ENG-AASI20002-R1-PDR-redlines.pdf Markup Summary

Pike Solar Development
Drainage Map
 Sheet 2 of 2
 El Paso County, CO

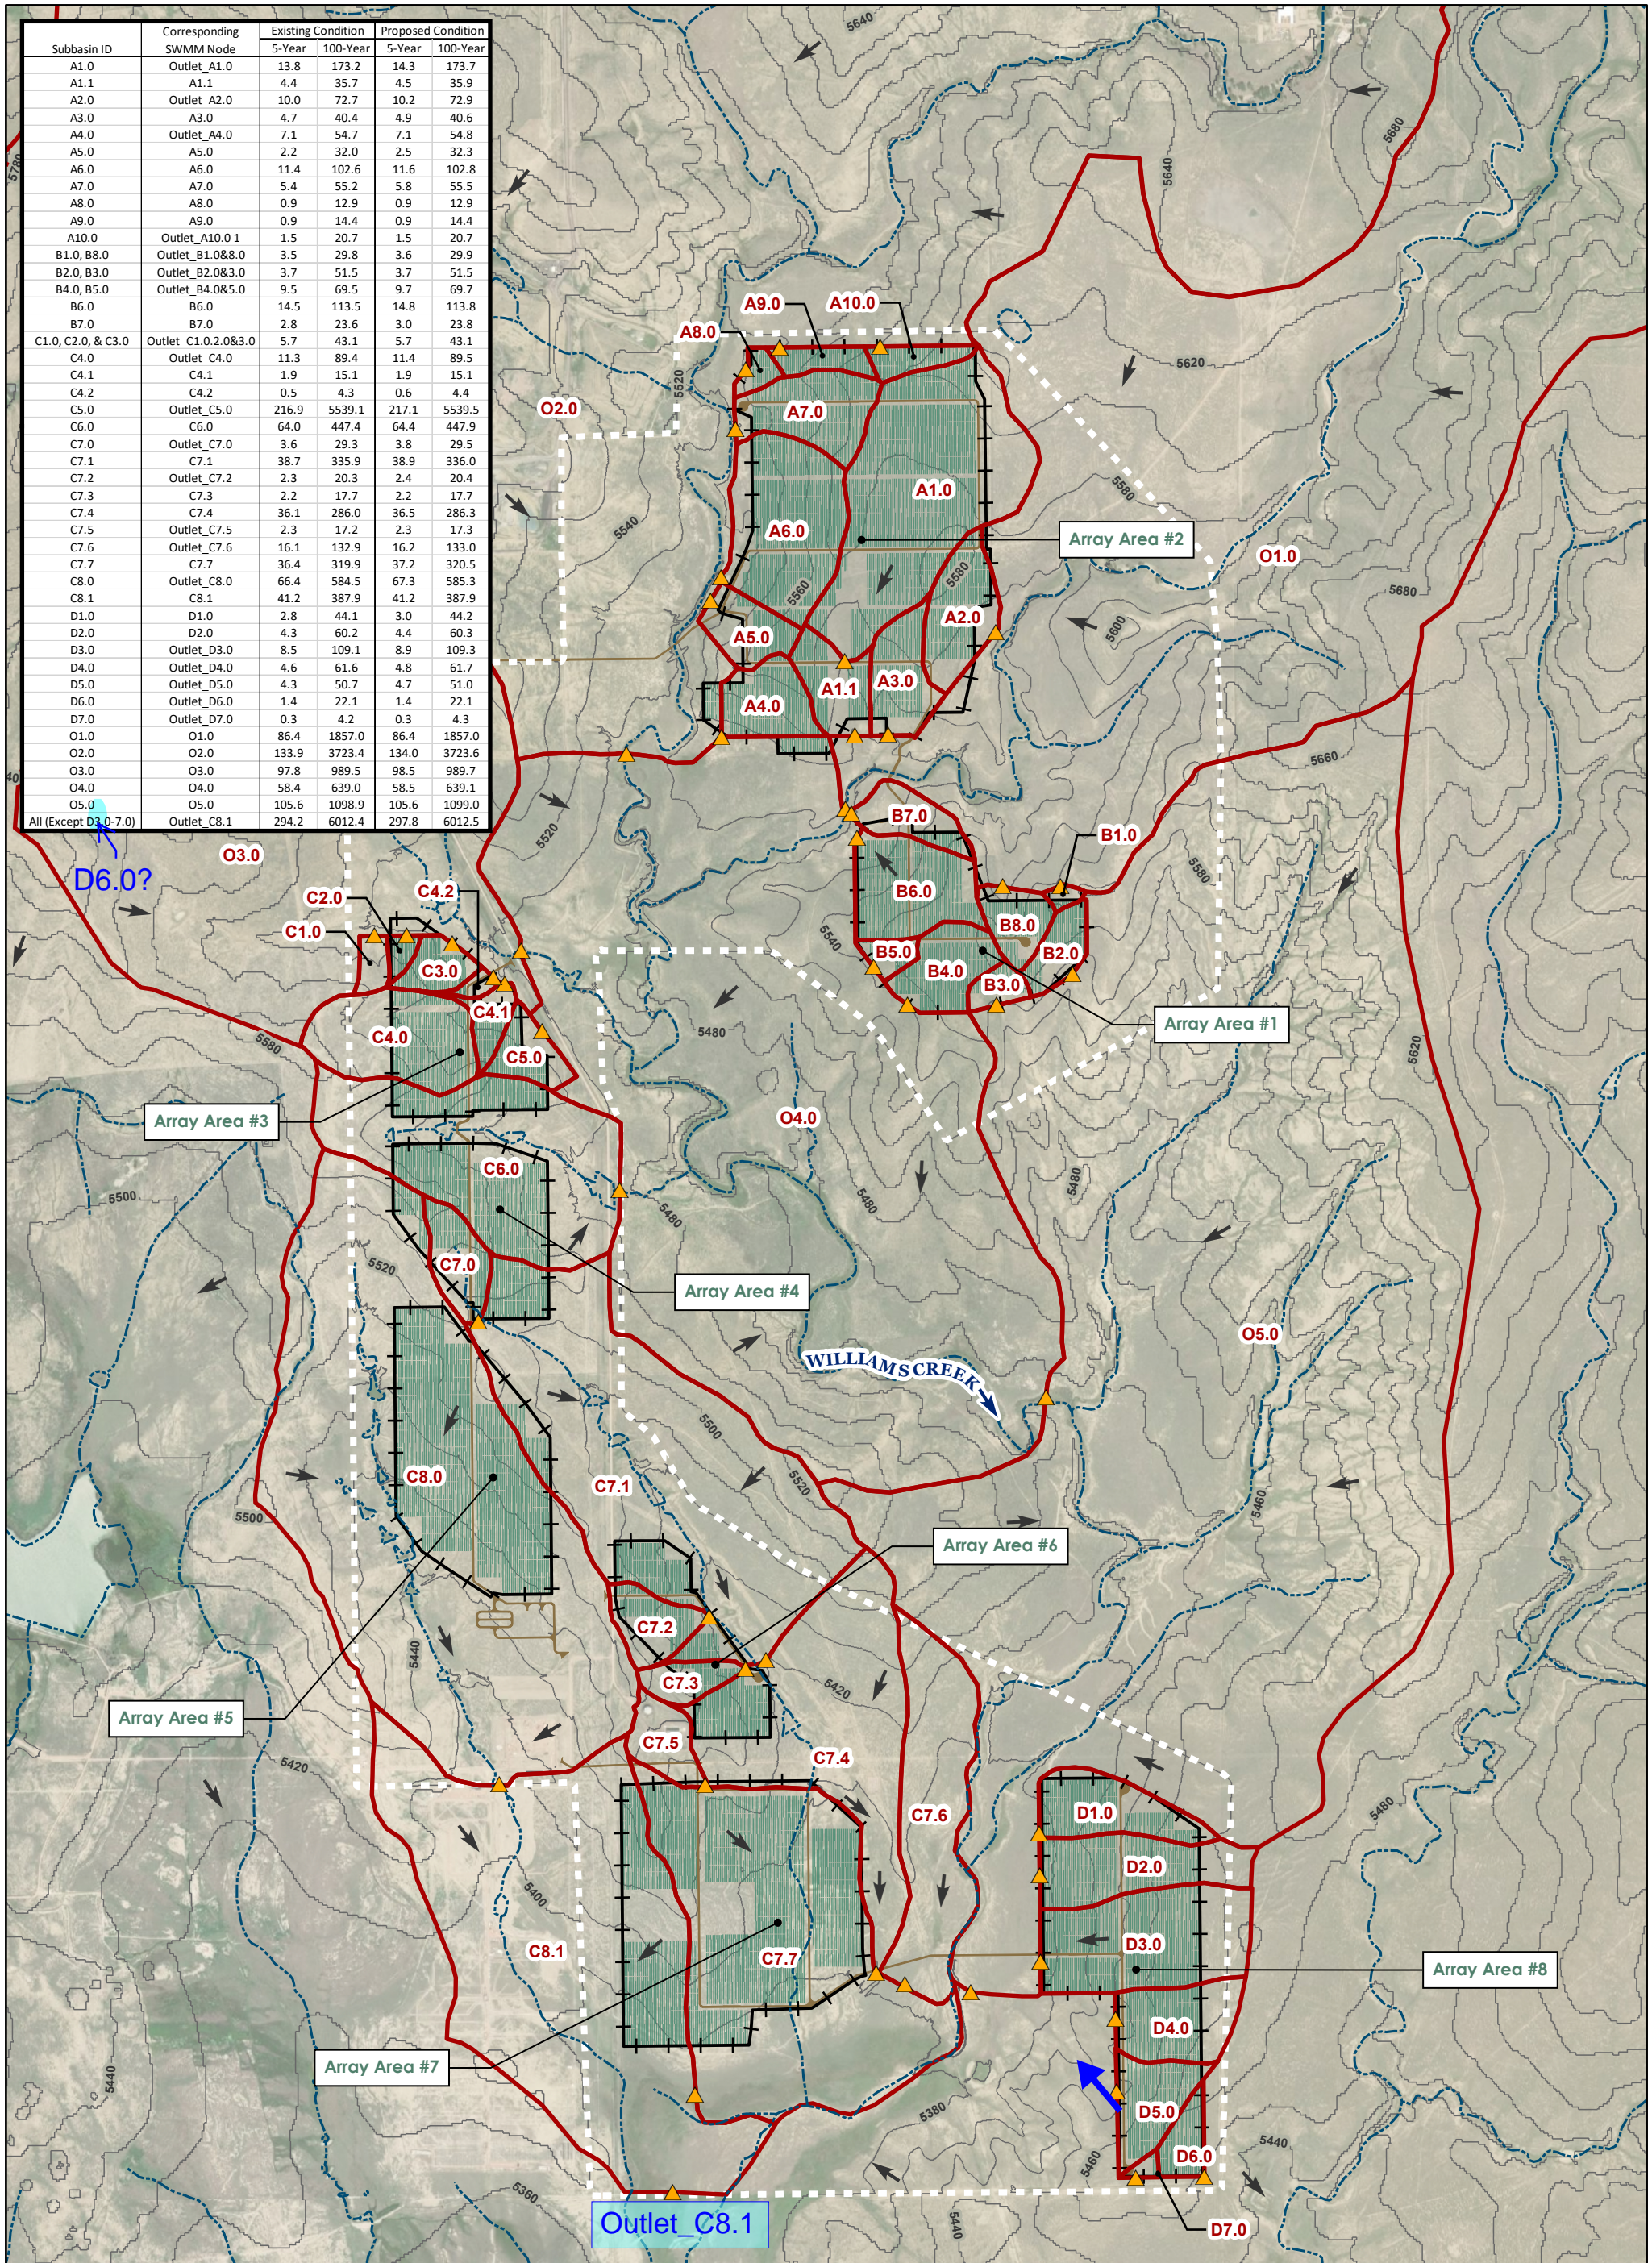
D6.0?

SWMM SUMMARY REPORT FOR 5-YEAR EXISTING CONDITION

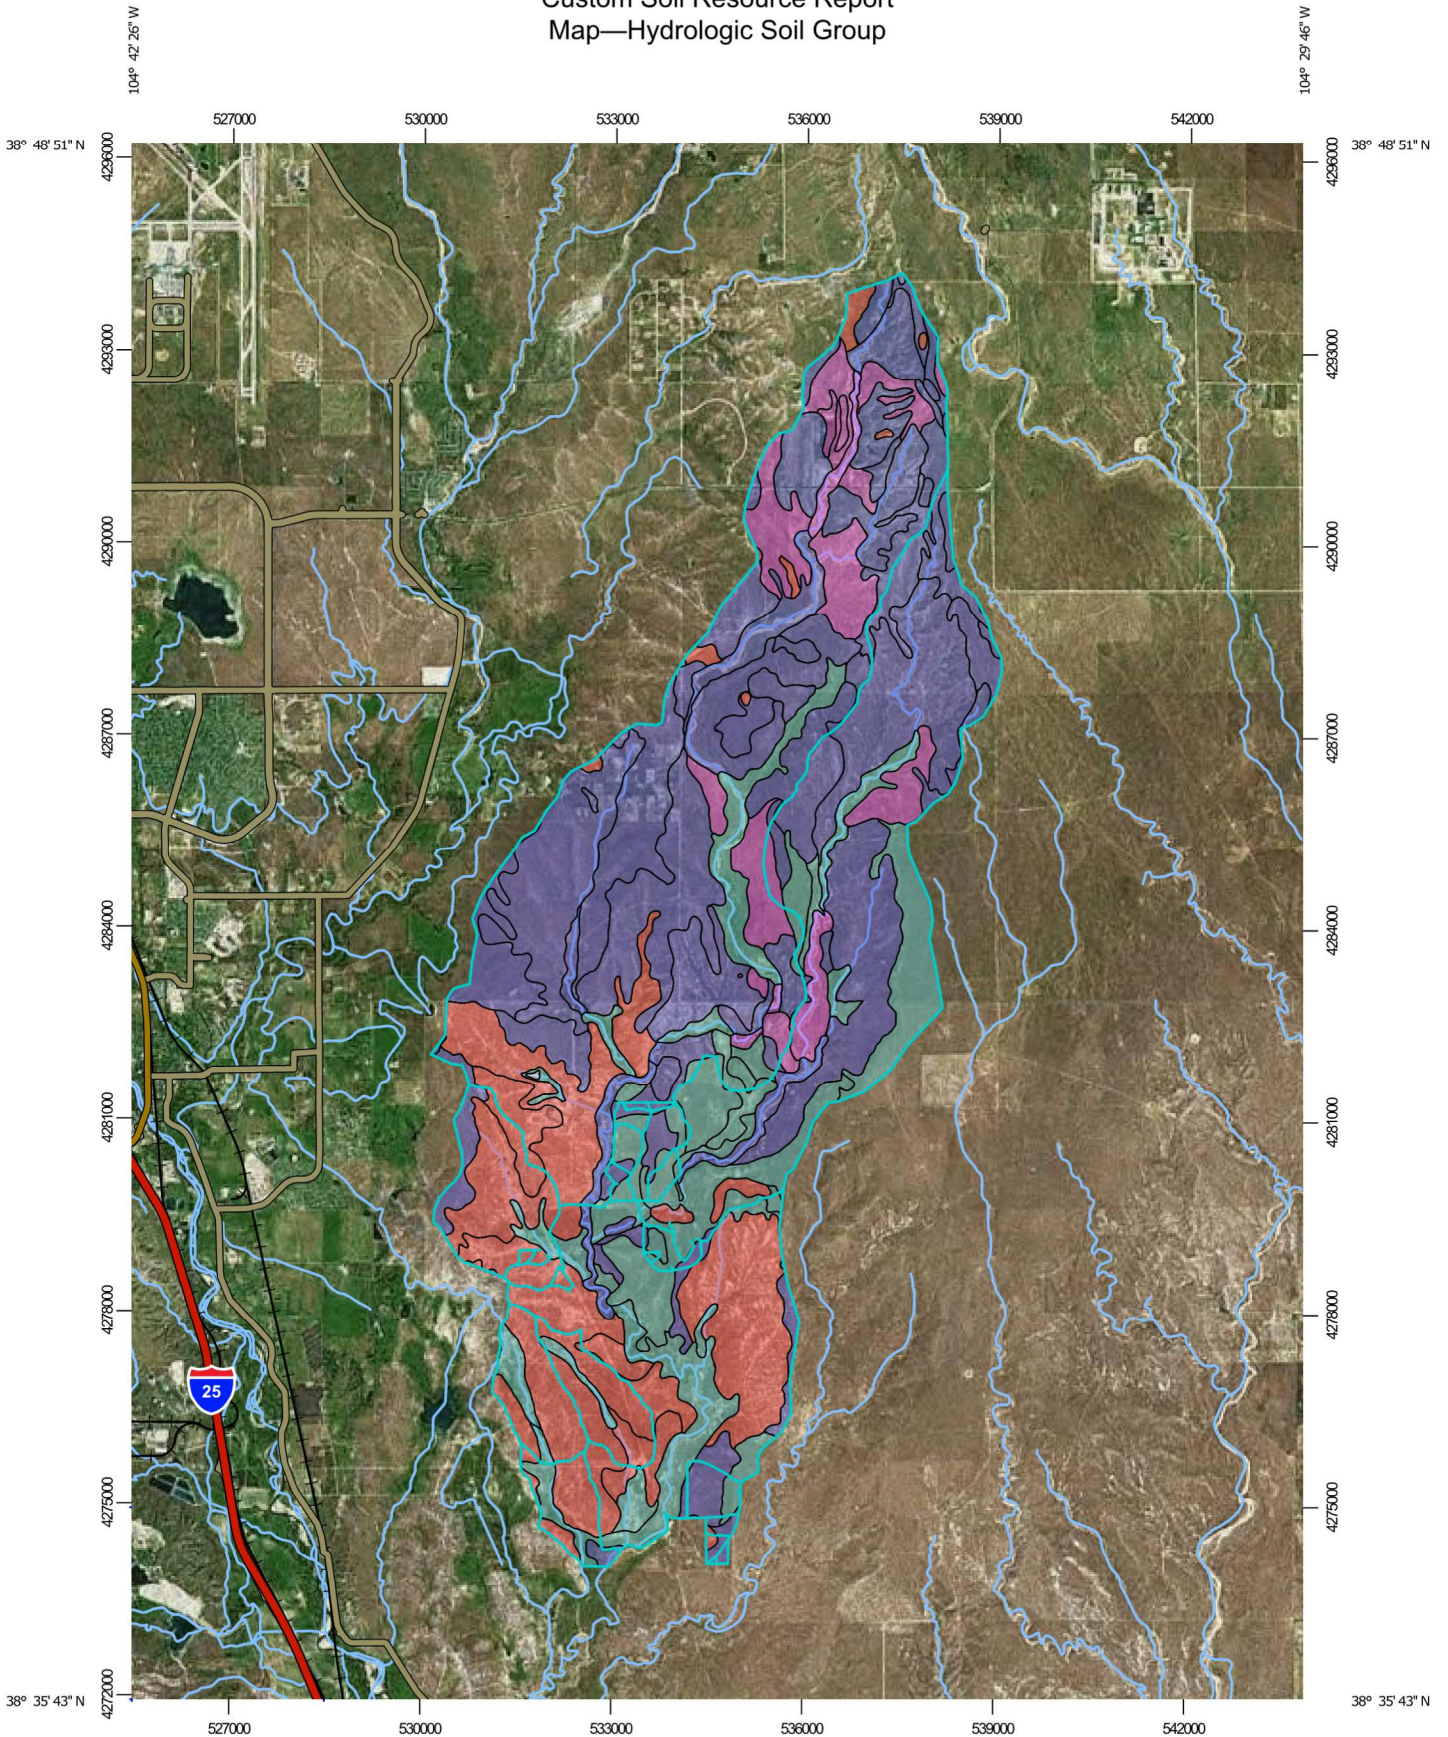
Add columns for quantity and % increase for 5- and 100-year values

Existing / Proposed Hydrology Comparison Table
